RE: **Stormcloud Units 4A & 4B Supplemental Calculations**
Engineer's Stamp Date: 03/13/2018
Hydrology File: H09D022A

Based on the information provided in the Drainage Report Supplement received on 3/14/2018 the above-referenced application is approved for Work Order and Grading Permit.

POND SHALL BE CONSTRUCTED WITH WORK ORDER PLANS
FIRST FLUSH POND
SCALE: 1"=20'

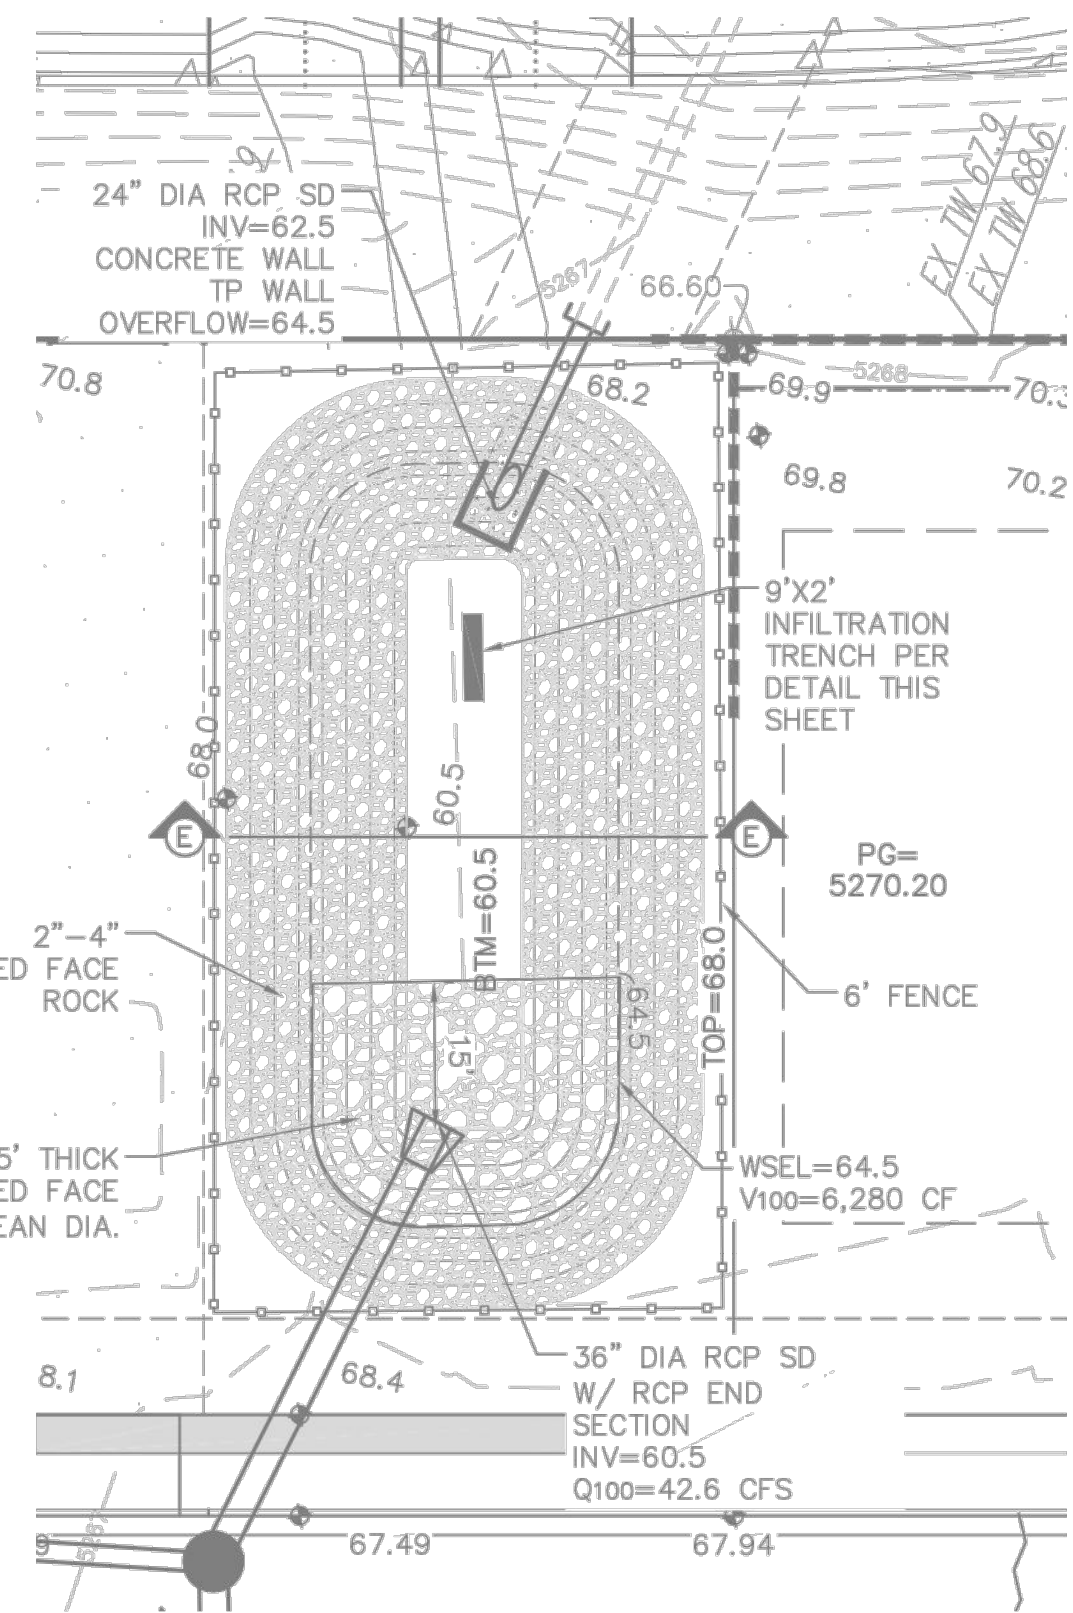
Prior to constructing the additional grading in the Unit 4A pond please submit shop drawings with sections showing horizontal and vertical dimensions to the property line and the fence and materials specifications to DRC. Please copy both AMAFCA and Hydrology with the shop drawings and sections.
